Your ref:
Our ref: 23/00032/F
Please ask for: Luke Swales
Direct dial: 01553 616865
E-mail: borough.planning@west-norfolk.gov.uk

TOWN AND COUNTRY PLANNING ACT 1990

Details: **Demolition of conservatory and erection of single storey side extension, single storey rear extension and double storey side extension at 19 Hawthorn Road Gayton King's Lynn Norfolk PE32 1UW**

Proposed Elevations

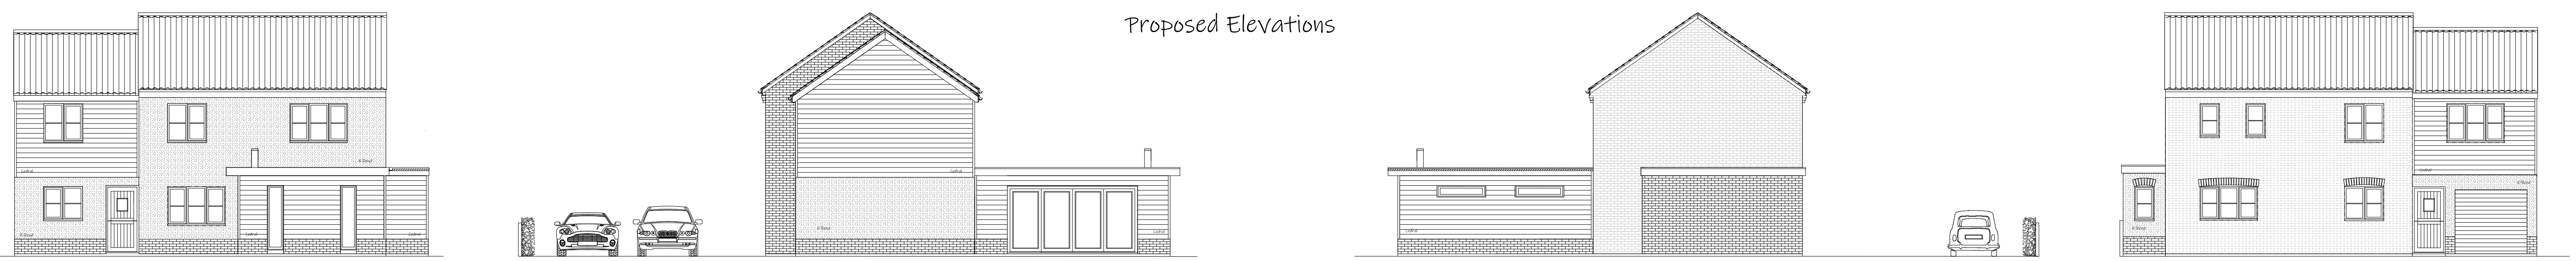
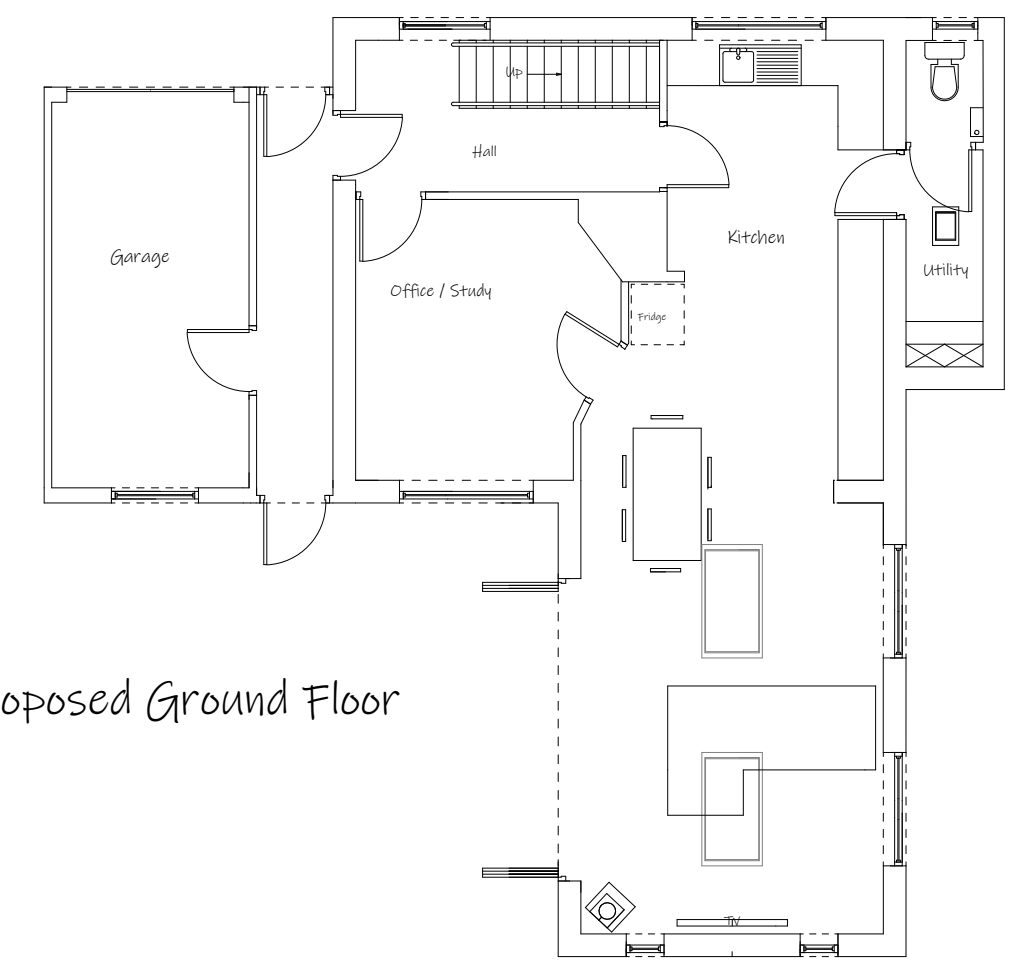
1. It appears that the dimensions of the folding door on the proposed west elevation does not match that of the proposed ground floor plan. On the elevation it measures 4m wide, however on the floor plan it measures 3.64m wide. Please amend the drawings to make the dimensions match.
2. As your proposal lies within an area susceptible to flooding a simplified flood risk matrix will be required. You can get the form from the following link: https://www.west-norfolk.gov.uk/download/downloads/id/5811/sfra_proforma_-_householder.pdf. Please mark the following on the form: Other Matters Surface Water and Reservoir Flooding.
